From: [BT Email](#)
To: [Planning Comments \(Shared Mailbox\)](#)
Subject: Reference: 6/2022/2586/HOUSE 61 The Ridgeway, ENG 4BD
Date: 08 December 2022 16:49:28

We write with major concerns with respect to the closeness and impact of the proposed extension to the front of the property and would ask for your clarification of various points of issue as set out below.

| TITLE: | Proposed Elevations. | | |

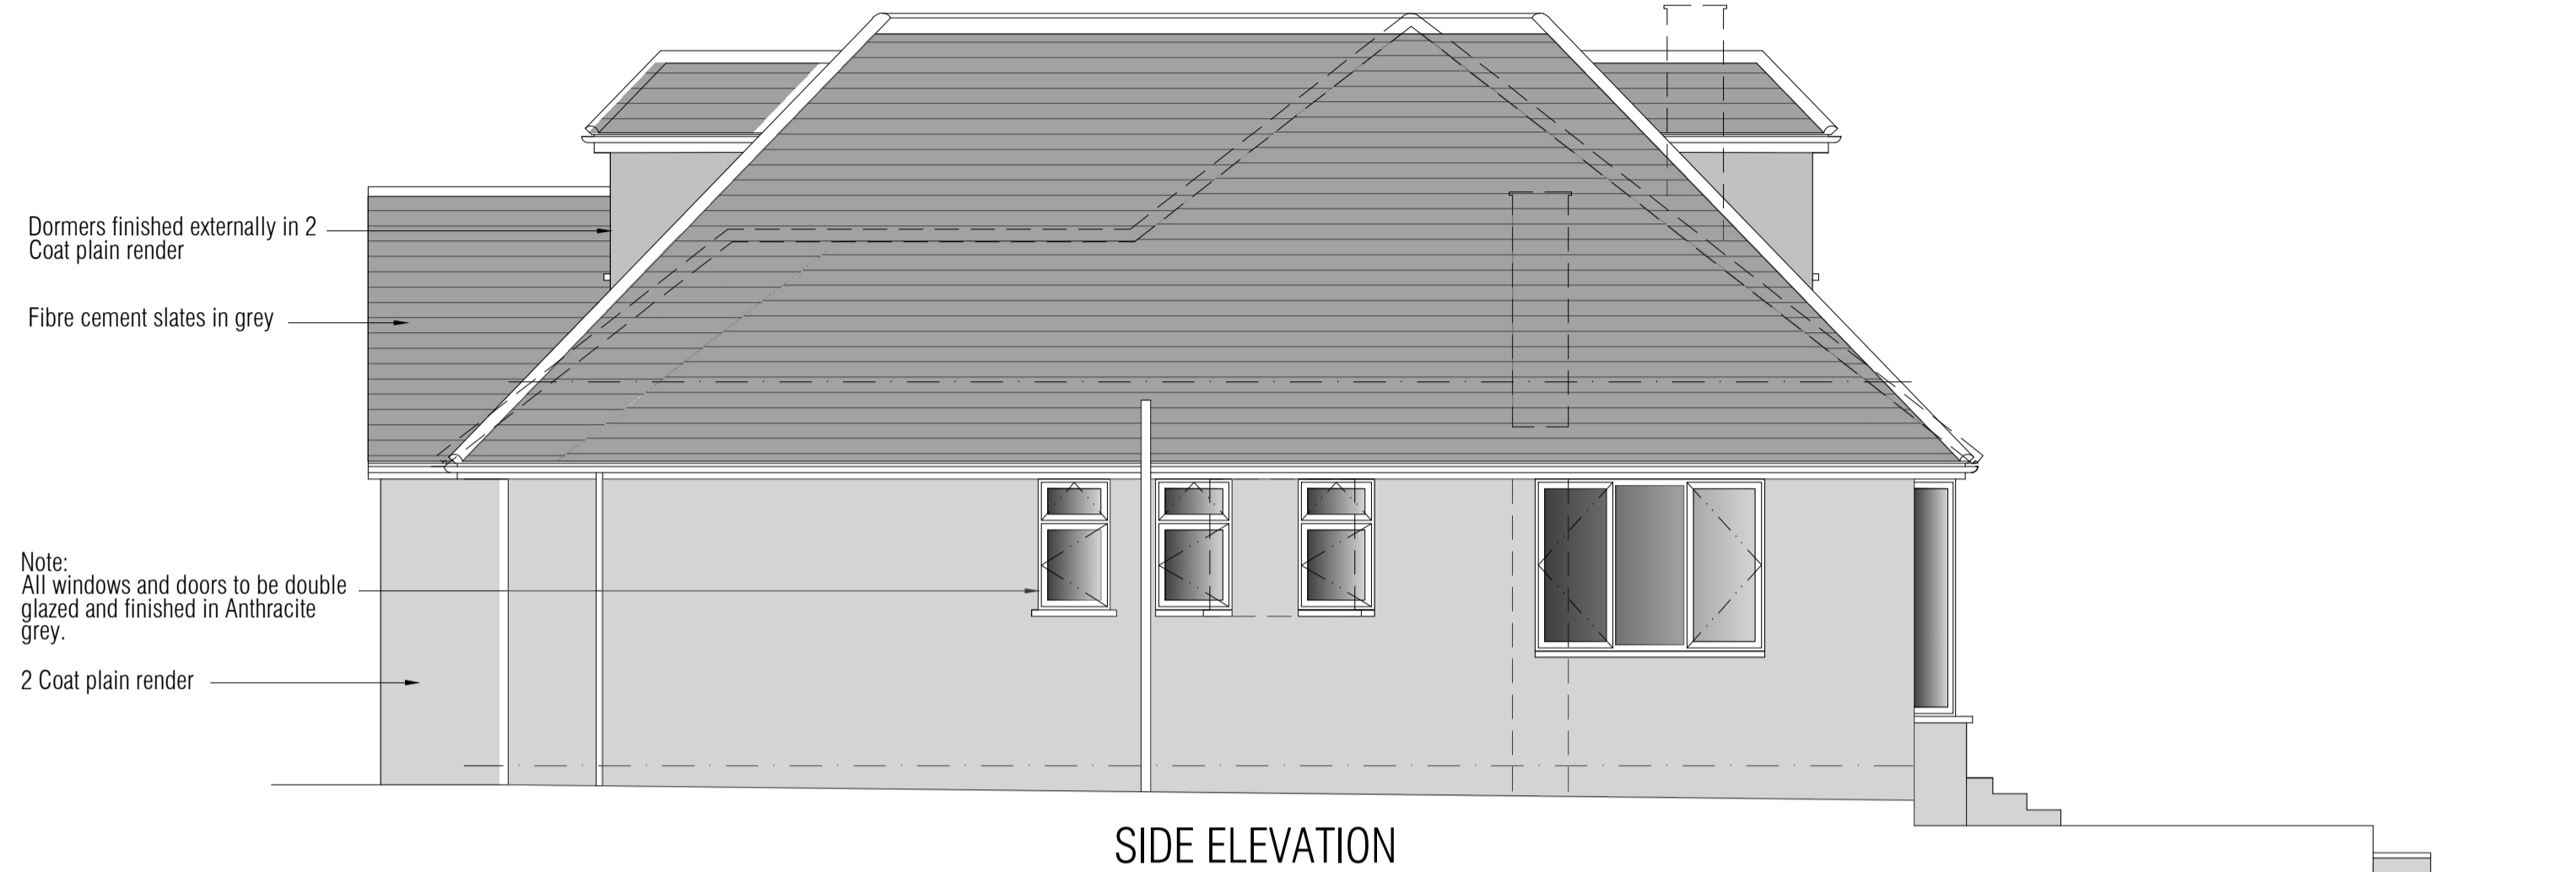
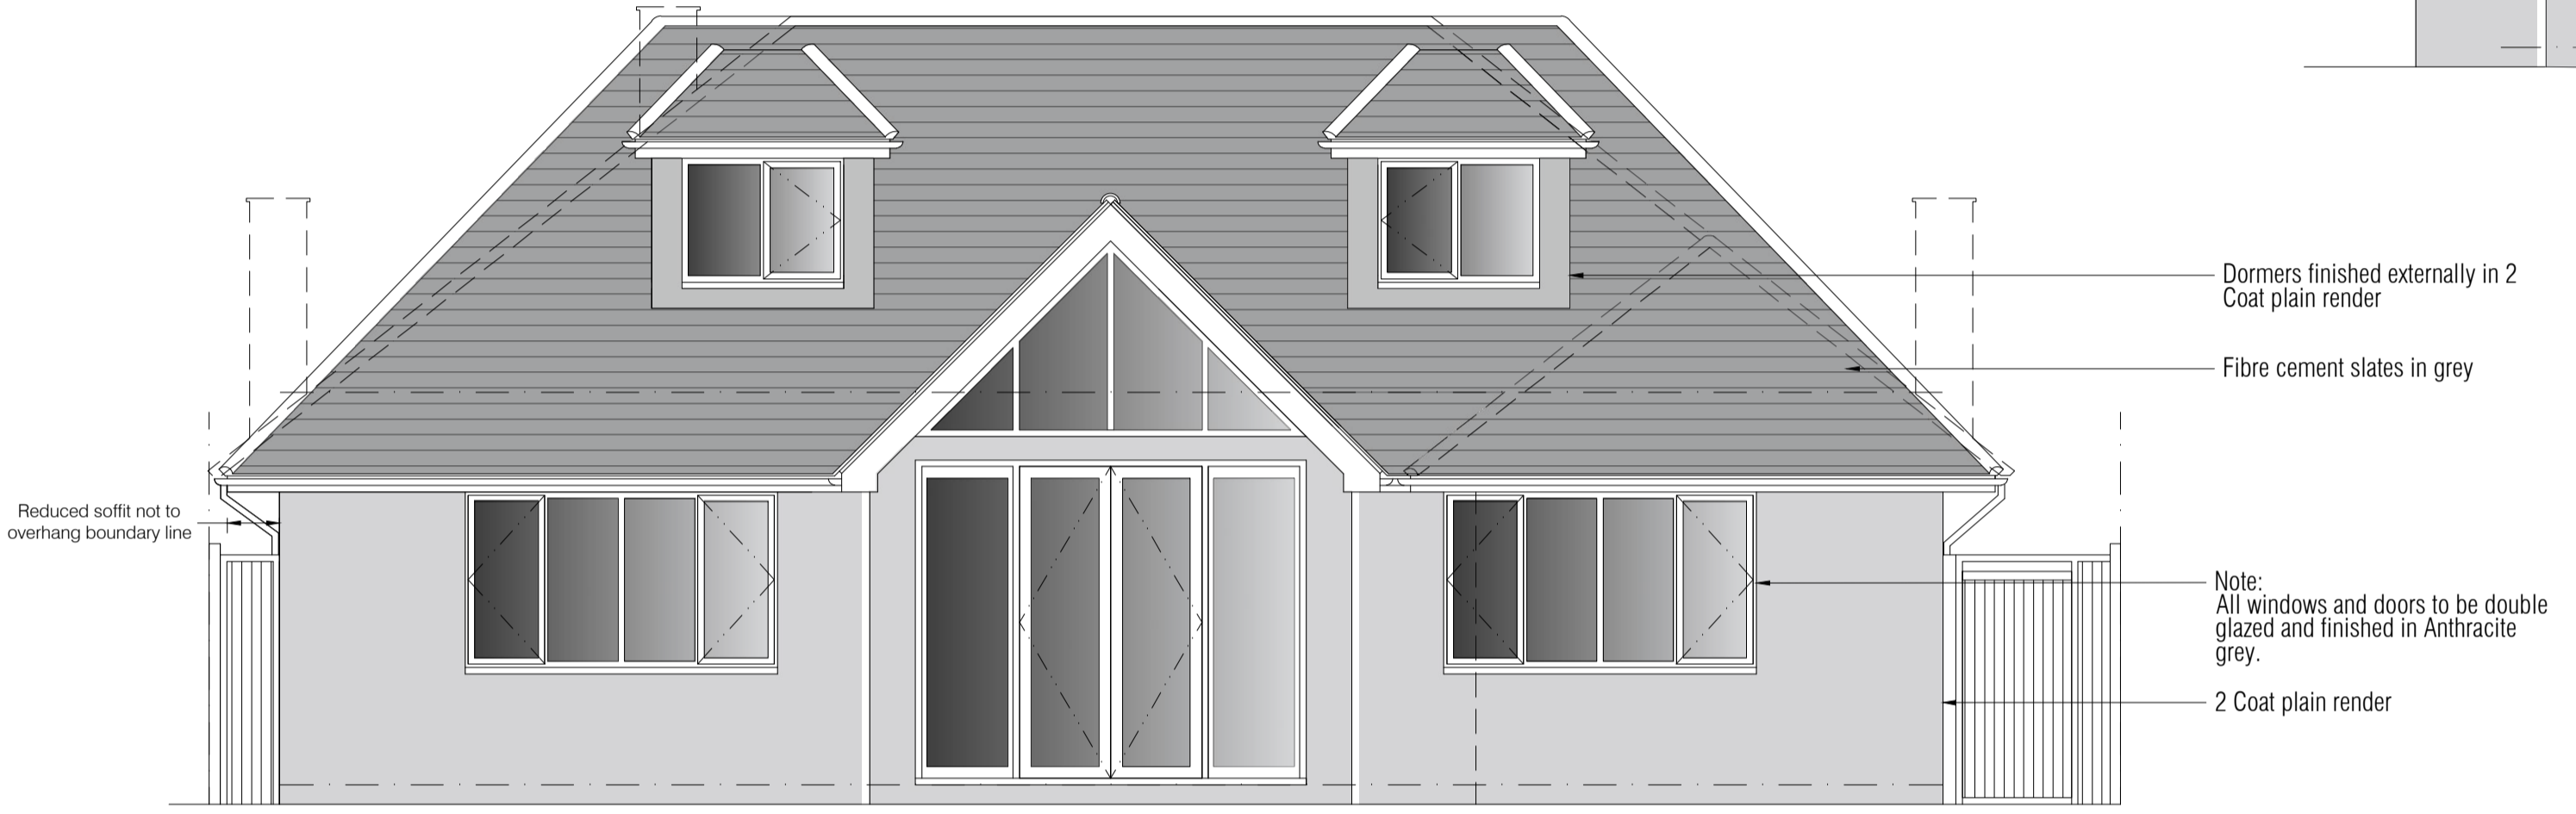
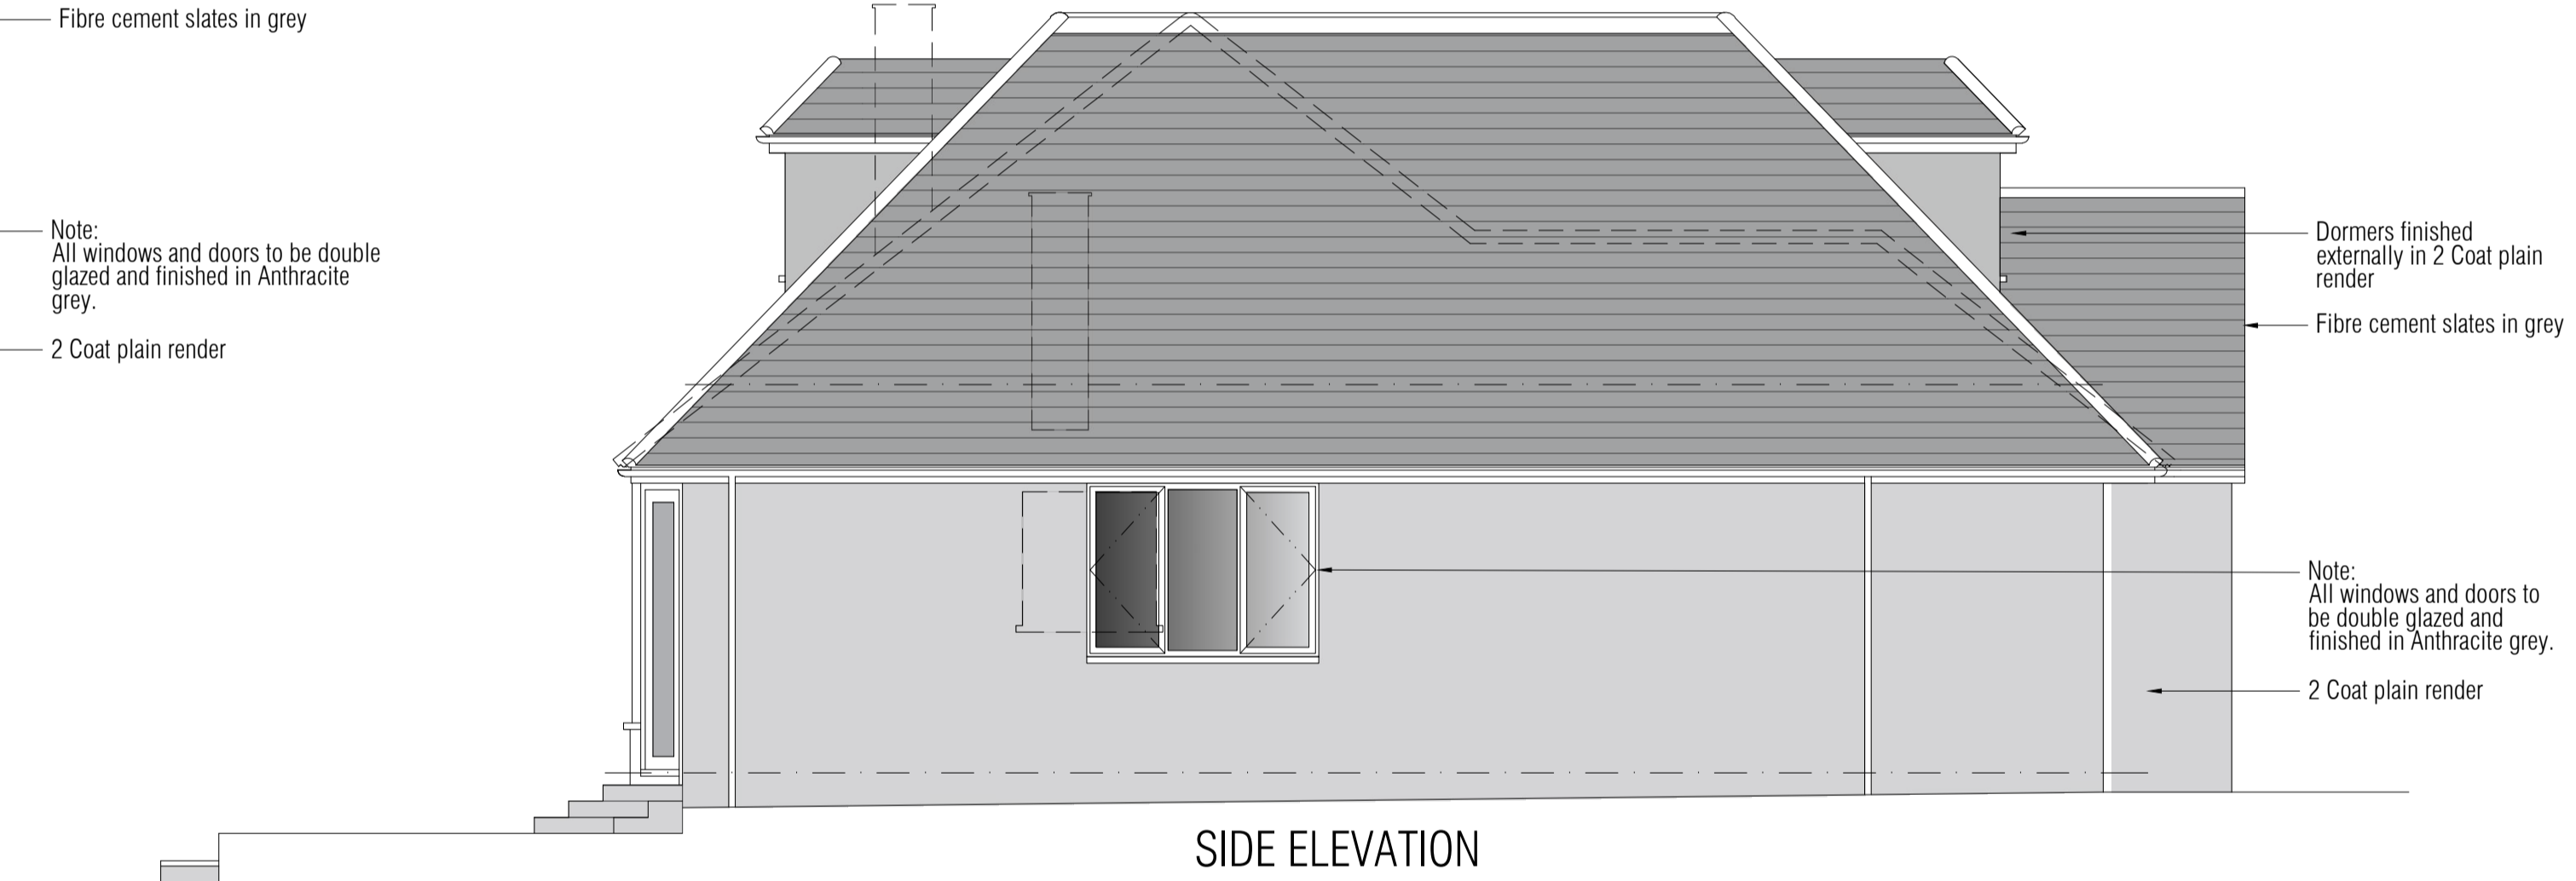
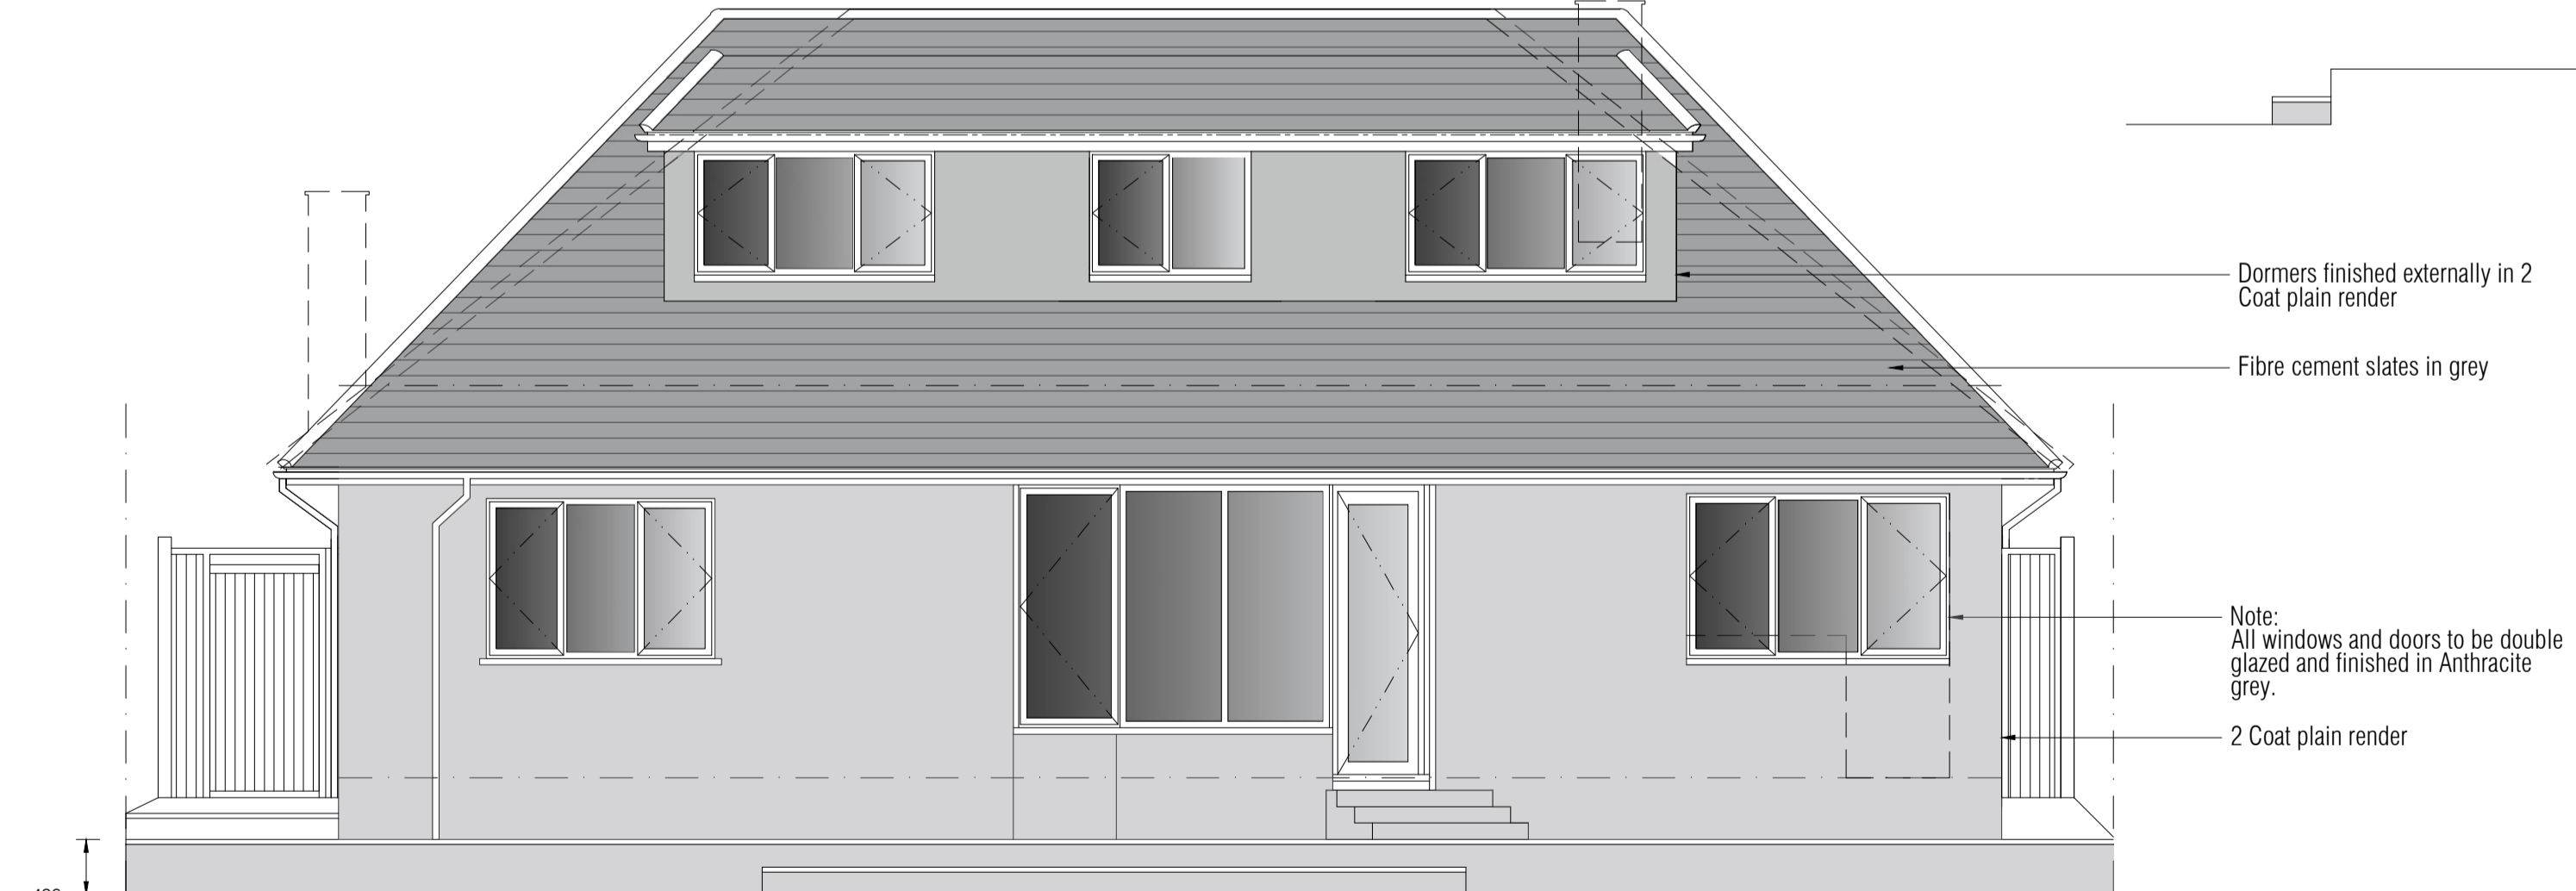
The actual large soffit/facia/guttering detail is shown on drawings to be maintained ? will this be reduced due to new roof pitch work and dimensions specified?

The proposed replacement of a side window for the Kitchen/Dinning room should be of a frosted glass nature as we will be able to see directly into this from our kitchen side door which is also our fire exit to this side of our building.
